From: [Adam Osbekoff](#)
To: [Jeremiah Cromie](#)
Subject: RE: RU-22-00004 Marlatt - Notice of Application
Date: Wednesday, November 23, 2022 8:46:51 AM

From: [Downes, Scott G \(DFW\)](#)
To: [Jeremiah Cromie](#)
Cc: [Torrey, Elizabeth M \(DFW\)](#)
Subject: RE: RU-22-00004 Marlatt - Notice of Application WDFW Comments
Date: Monday, November 28, 2022 9:15:41 AM

Re: RU-22-00004 Marlatt

TO: All Staff
FROM: Public Works Plan Review Team
DATE: December 12, 2022
SUBJECT: RU-22-00004 Marlatt

Figure 2. Wetland map of the study area.

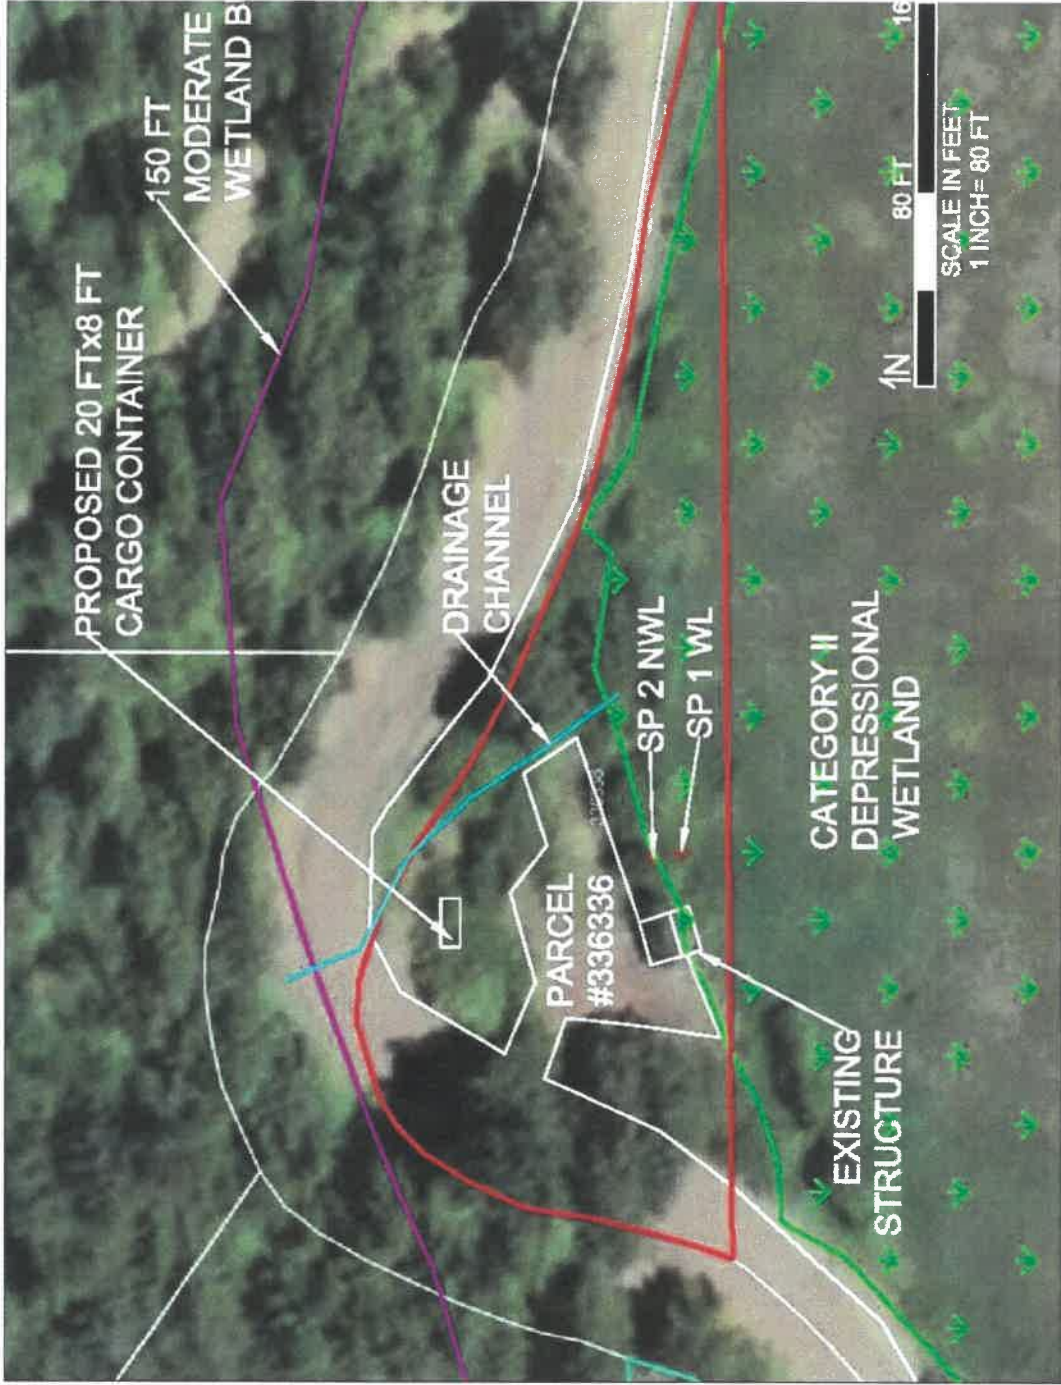
In addition to the wetland and associated buffer, there is a mapped Type N near where the cabin was placed and where the proposed cargo container is to be placed. WDFW would like to have a site visit to assess the stream, its location and the placement of the cargo container and cabin in relation to the stream. The discussion should also include potential mitigation if either are within the riparian zone for the Type N stream.

Thanks for sending. My follow-up question is has any agency been out to verify the proposed stream typing in the report? Yes, they are correct on an Ns needing surface connection, but we'd want to verify that this is an Ns as Np doesn't need surface connection and if it an Ns we'd want to verify that there is a lack of surface connection. If this has happened (agency has reviewed), then they should submit a Water Type Modification to remove this stream. If it hasn't, then WDFW or another agency needs to review the stream.

We can arrange a site visit if needed. They did address the stream channel (type N) in the report on page 4 saying it didn't qualify as a Type Ns as it does not connect to a higher order water by an above ground channel per [KCC 17A.04.020 \(4\)\(d\)](#) . Let me know if this changes any comments you may have. For reference, I have attached Grette's report.
